From: Peter Monk
Sent: 07 July 2019 22:56
To: Bob Duxbury
Subject: Our Ref:16/00472/OUT Grundon Ltd.

I write on behalf of Banbury Civic Society to thank you for the notification in respect of the above Application.

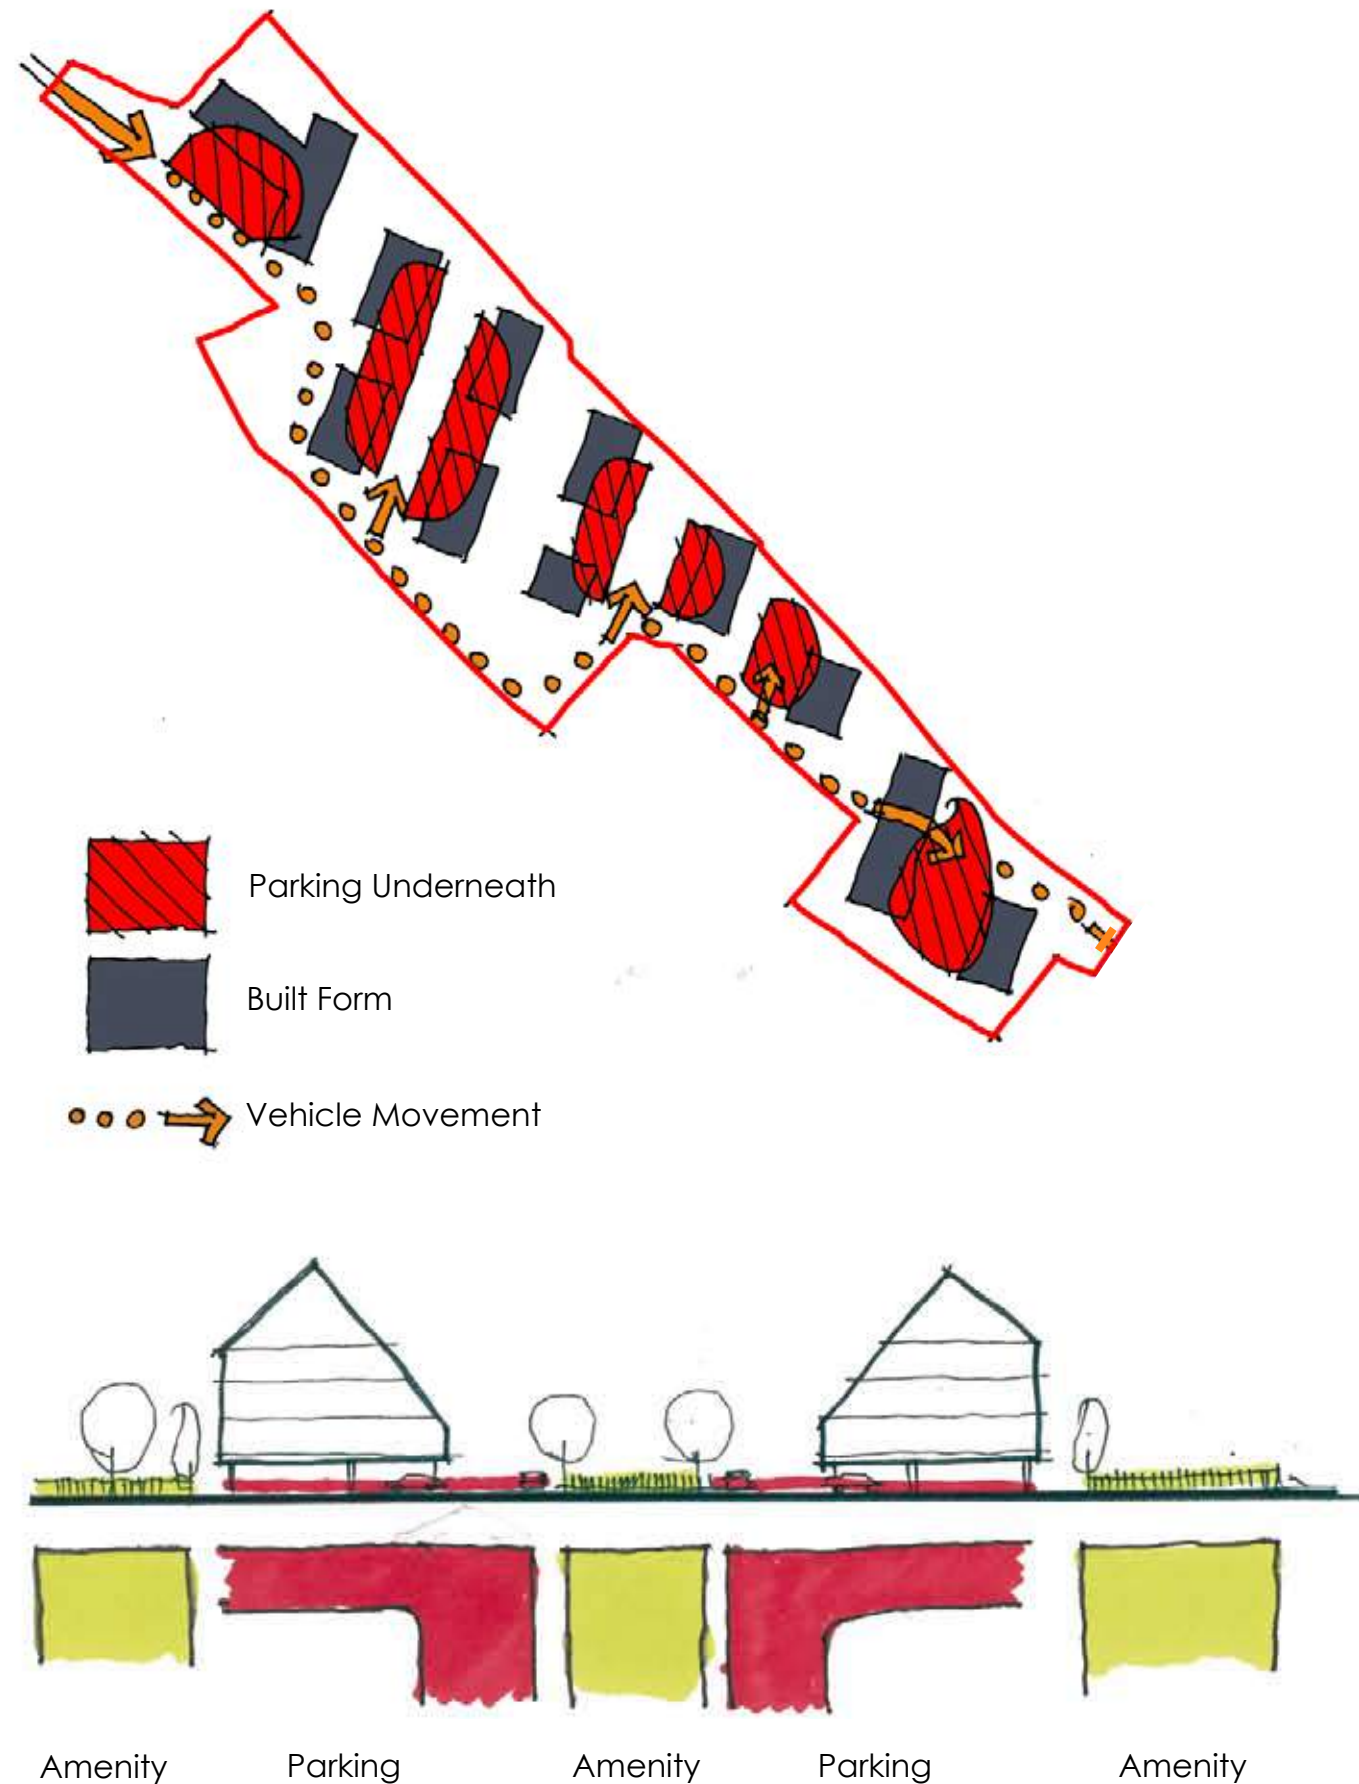
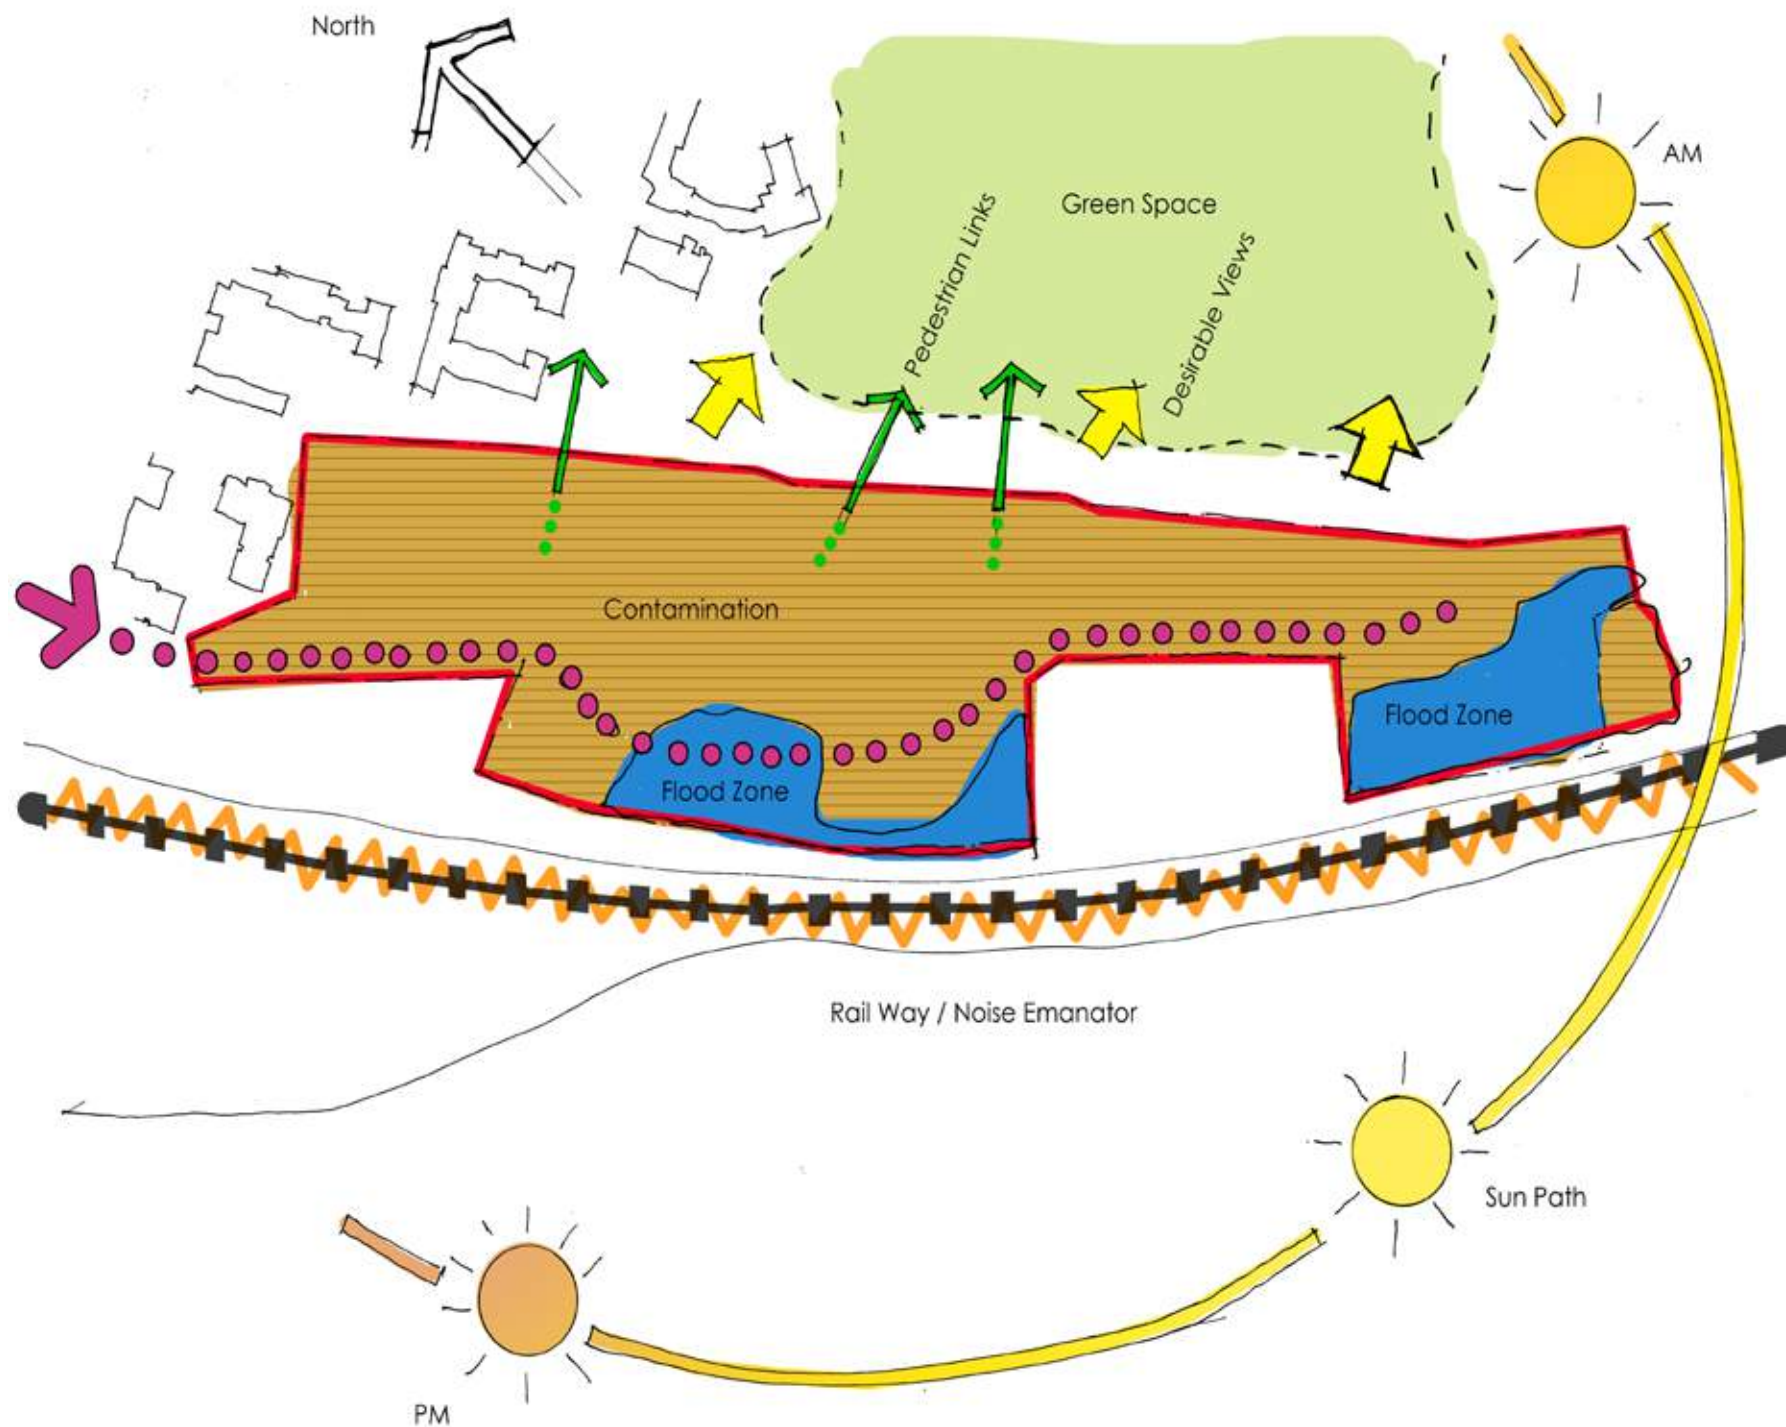
However, the Society is most concerned about retaining the long term possibility of extending Higham Way southwards to either a) connect with the proposed South-to-East link road between Bankside and Chalker Way (see Banbury Vision and Masterplan), OR b) to swing eastwards around the perimeter of Ban 6 also to link with Chalker Way, thereby also providing access possibilities to the presently undeveloped remainder of Ban 6. The Indicative Layout, as posted, does not engender confidence that either of these options would be possible.

Furthermore the alignment of Higham Way extension into the proposed development, as shown on the submitted drawings, is very much of 'switchback' in nature and is barely suitable for an estate access road. It would certainly not be suitable if a further extension southwards, as envisaged, is ultimately achieved.

If Committee is minded to support the southward extension of Higham Way, we would suggest a reappraisal of the layout in order to make it suitable for both those living nearby and those who might be using it as a through route to (say) the railway car park.
